WEST SUSSEX COUNTY COUNCIL CONSULTATION

TO:	Arun District Council FAO: Anita Gardner
FROM:	WSCC - Highways Authority
DATE:	22 November 2019
LOCATION:	Land rear of 1 The Heathers Arundel Road Angmering BN16 4LE
SUBJECT:	A/146/19/PL Demolition of existing storage building & erection of a 3-bedroom chalet bungalow with associated parking & landscaping.
DATE OF SITE VISIT:	n/a
RECOMMENDATION:	Advice
S106 CONTRIBUTION TOTAL:	n/a

P3	25.10.19	Revised notation.	JT	AK
P2	25.10.19	Revised red line and road name correction.	JT	AK
P1	17.10.19	Planning Issue.	JT	AK
Rev	Date	Revision Details	Dr	Ch

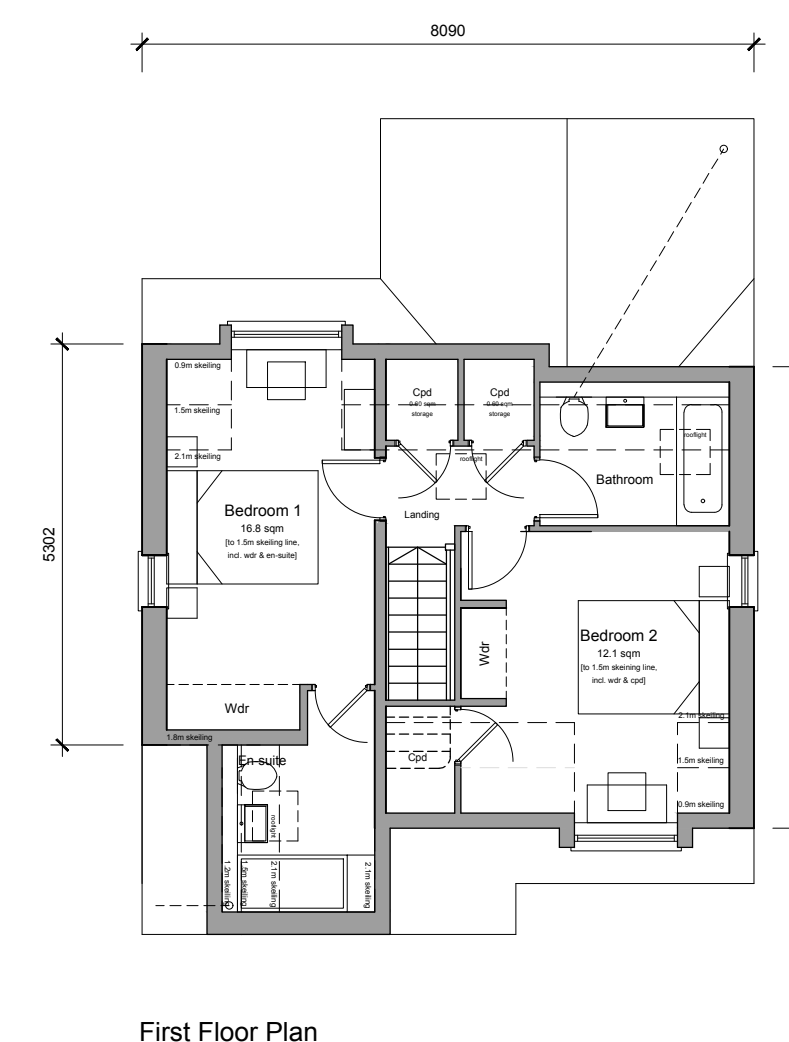
A second access is located on foot via Lansdowne Way to Goring Close a publicly maintained footway. It appears that the gate/access path from the footway to the dwelling may result in a conflict with a street lighting pole. The applicant is advised to contact the operator in regards to the possible relocation works associated.

After inspection of these plans, the LHA advise that the garage (2.6 x 5.3 metres) does not conform to WSCC and Manual for Streets (MfS) guidance for garage dimensions (3 x 6 metres). On this basis the LHA will not consider the garage towards the parking provision of the site.
